CD V_2.pdf Markup Summary

GEC V_2.pdf Markup Summary

DATE: SEPT 15, 2018
 PROJECT NO: 100.044
 SHEET NUMBER: **C4.3**
 TOTAL SHEETS: 11

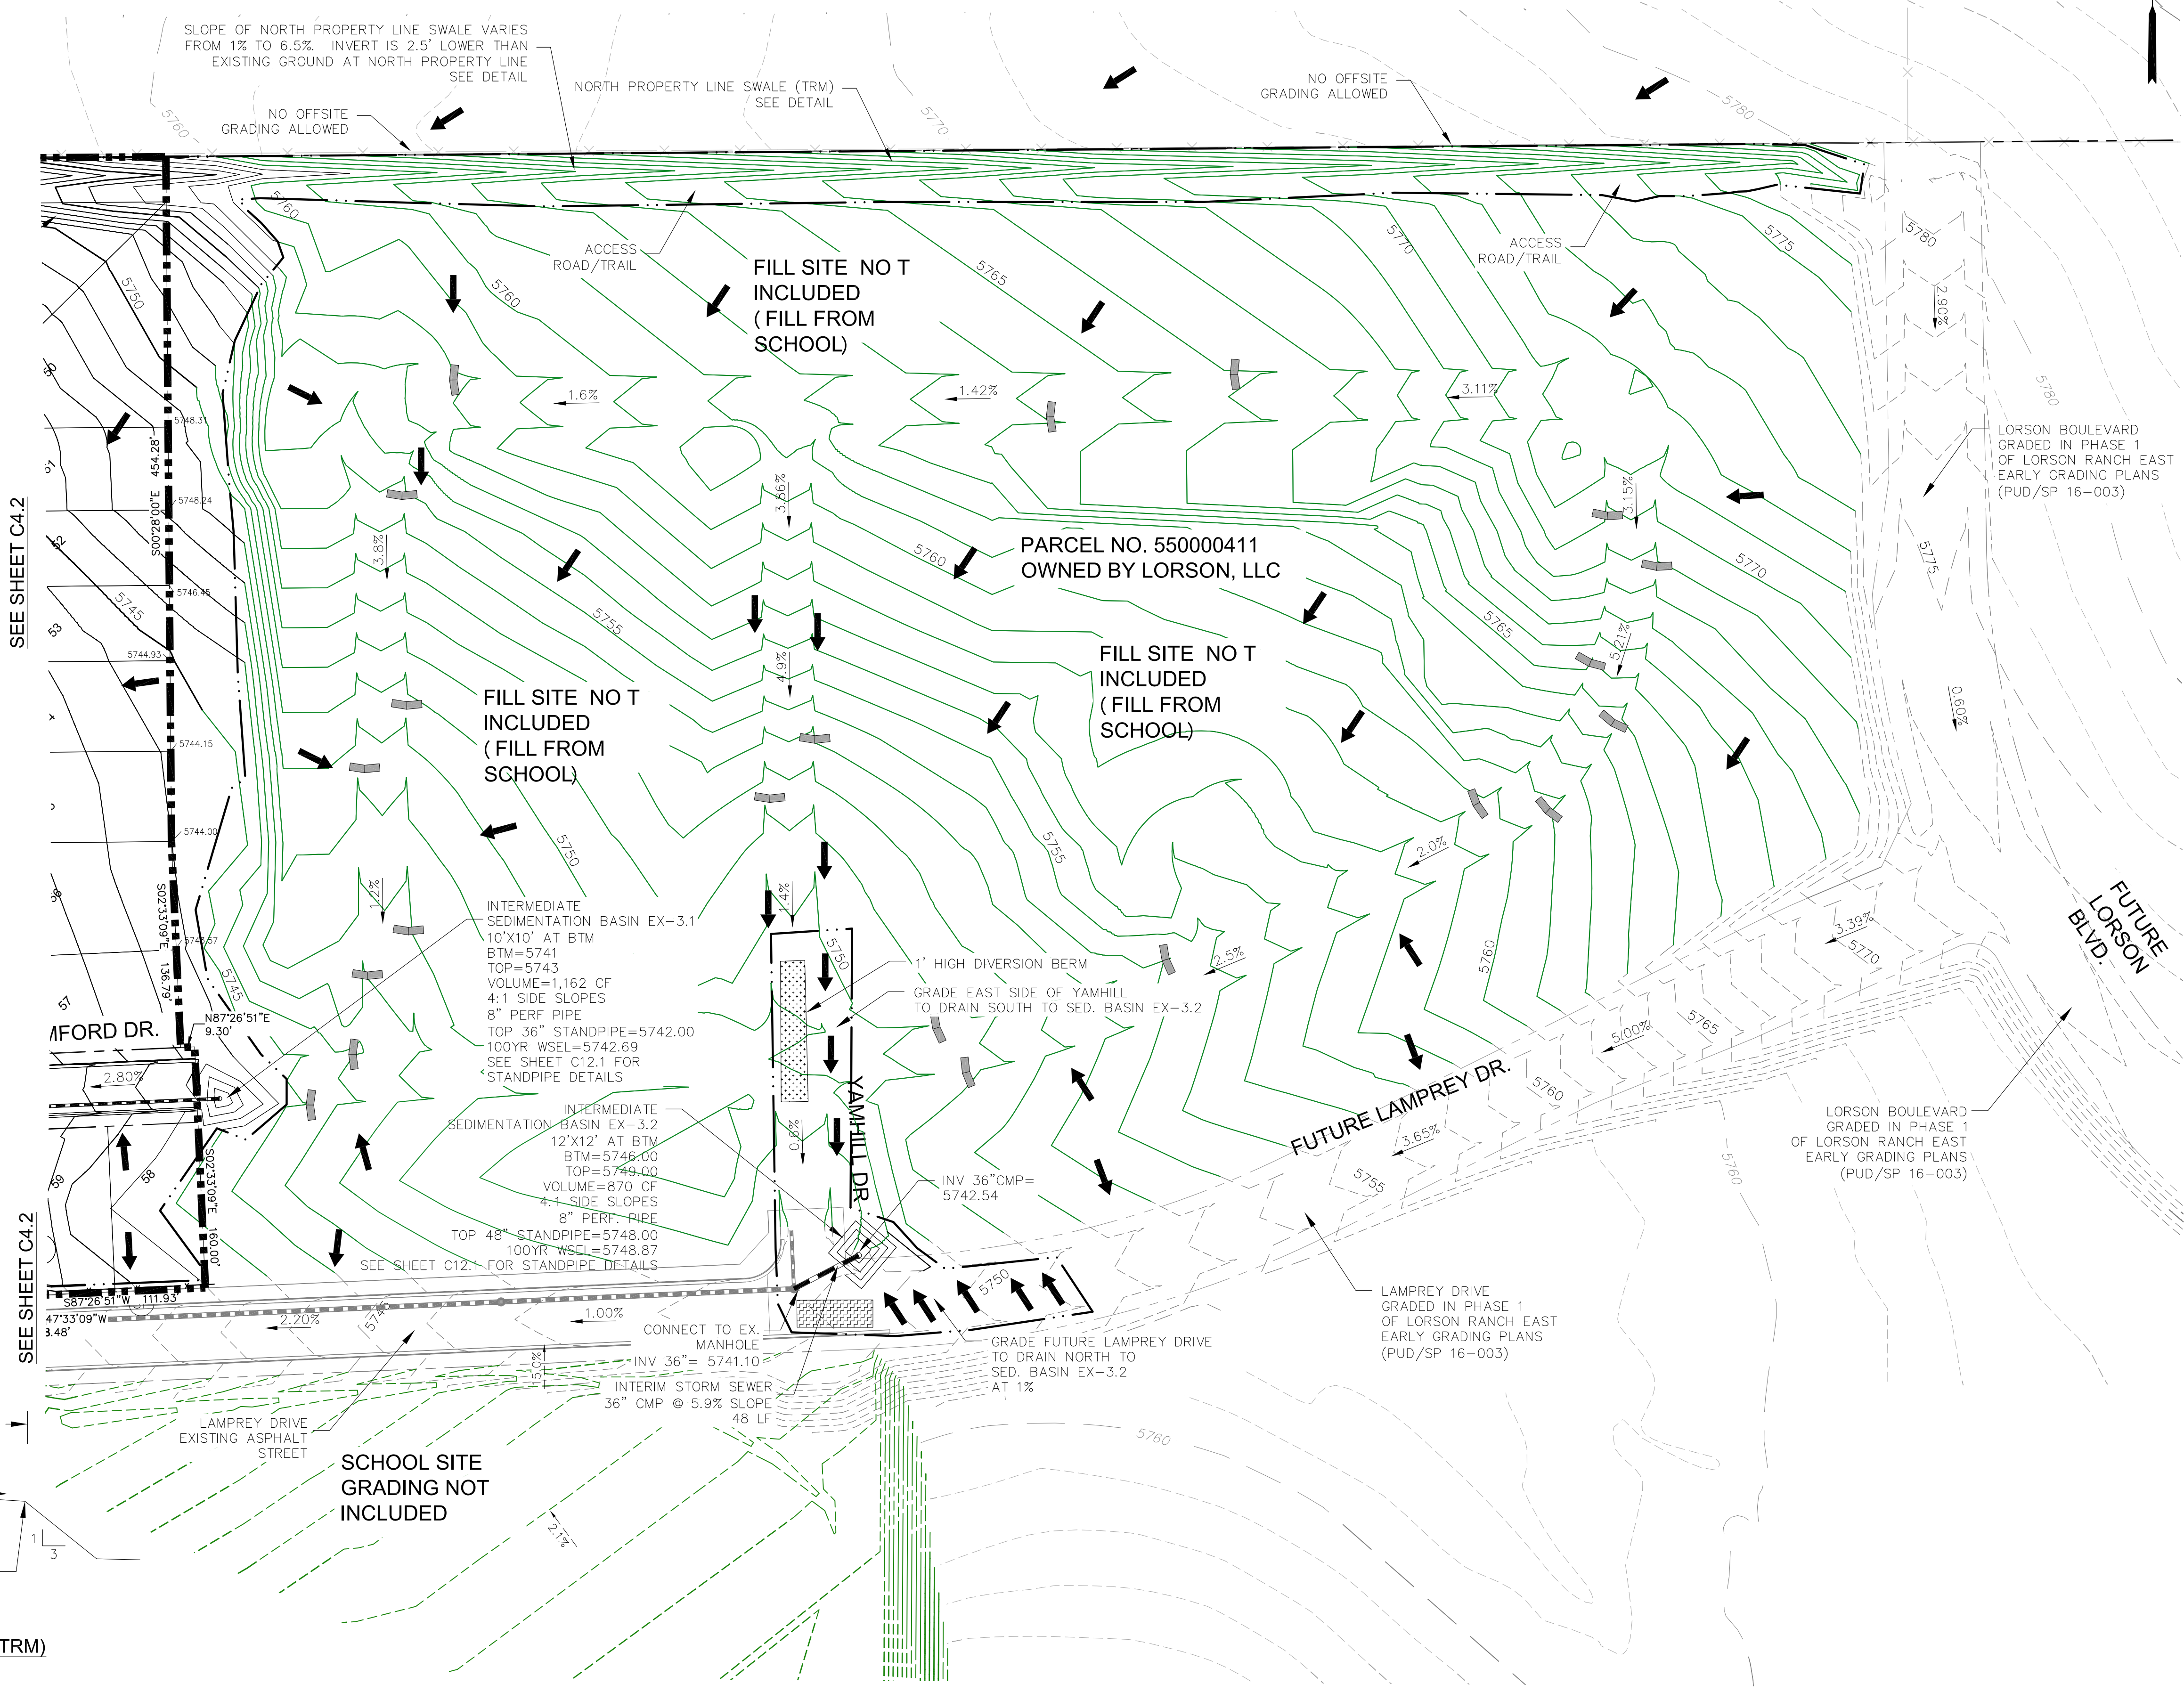
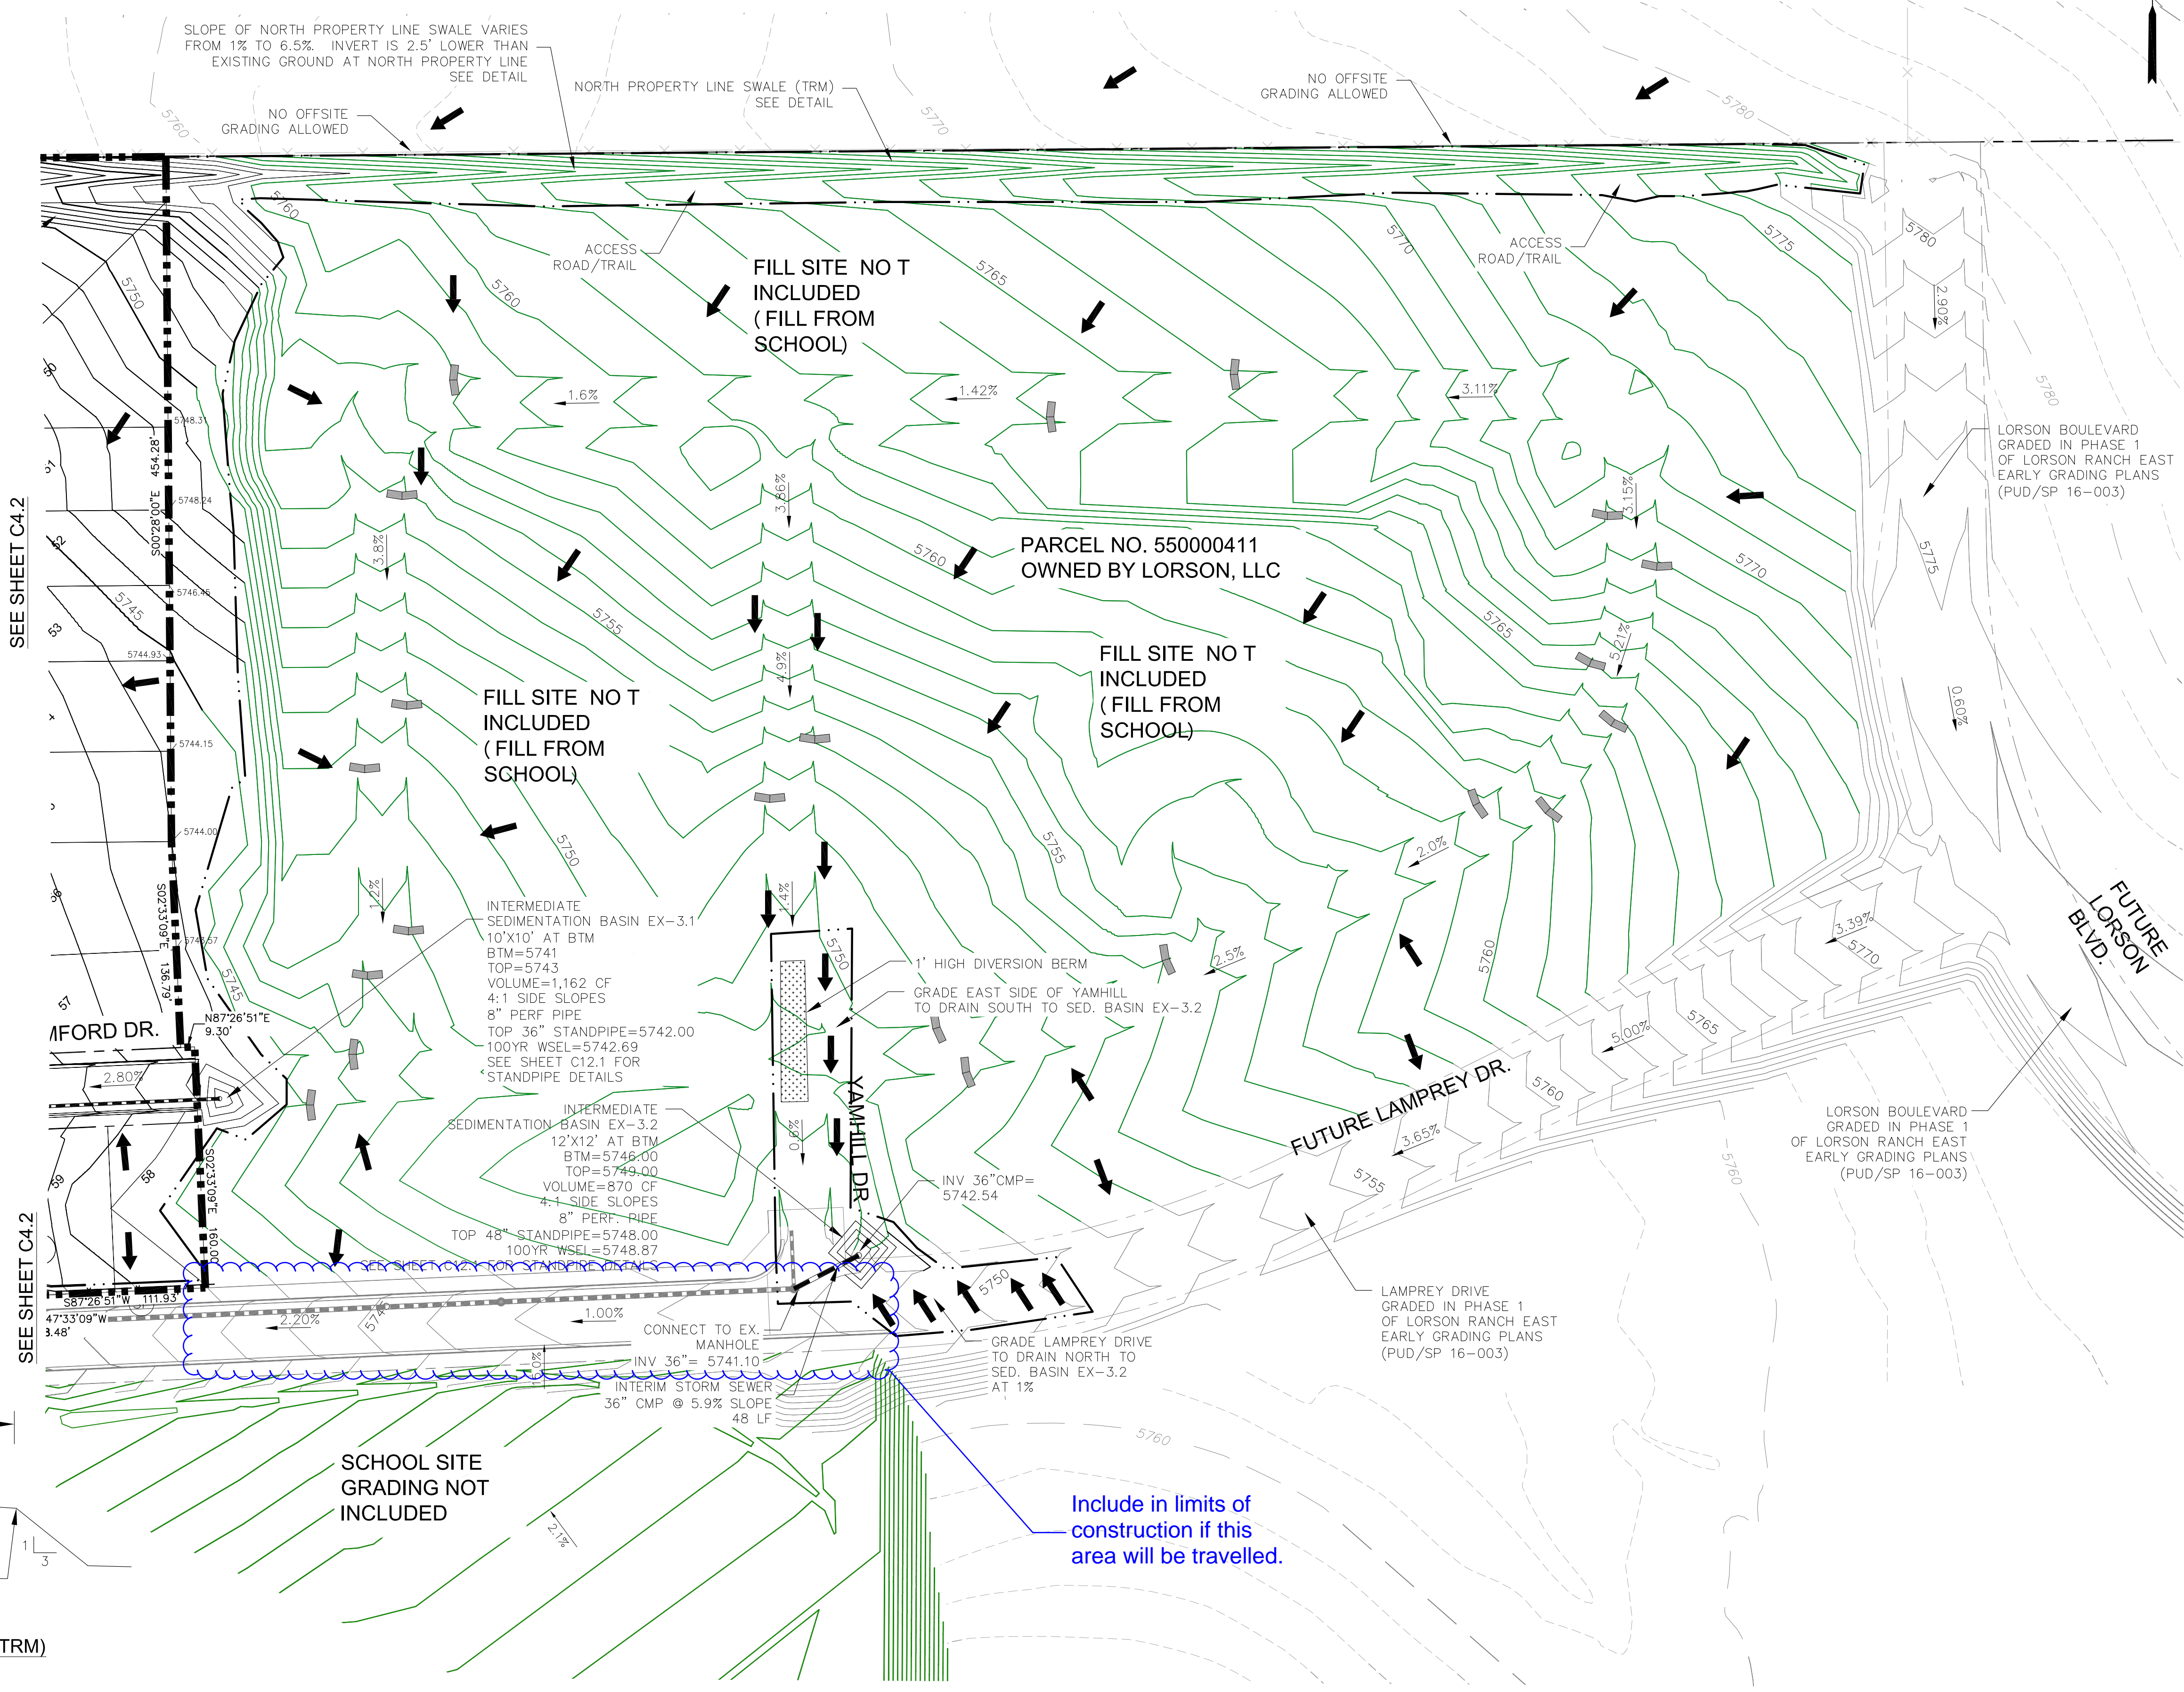
Show existing contours .

Change linetype if contours are existing.
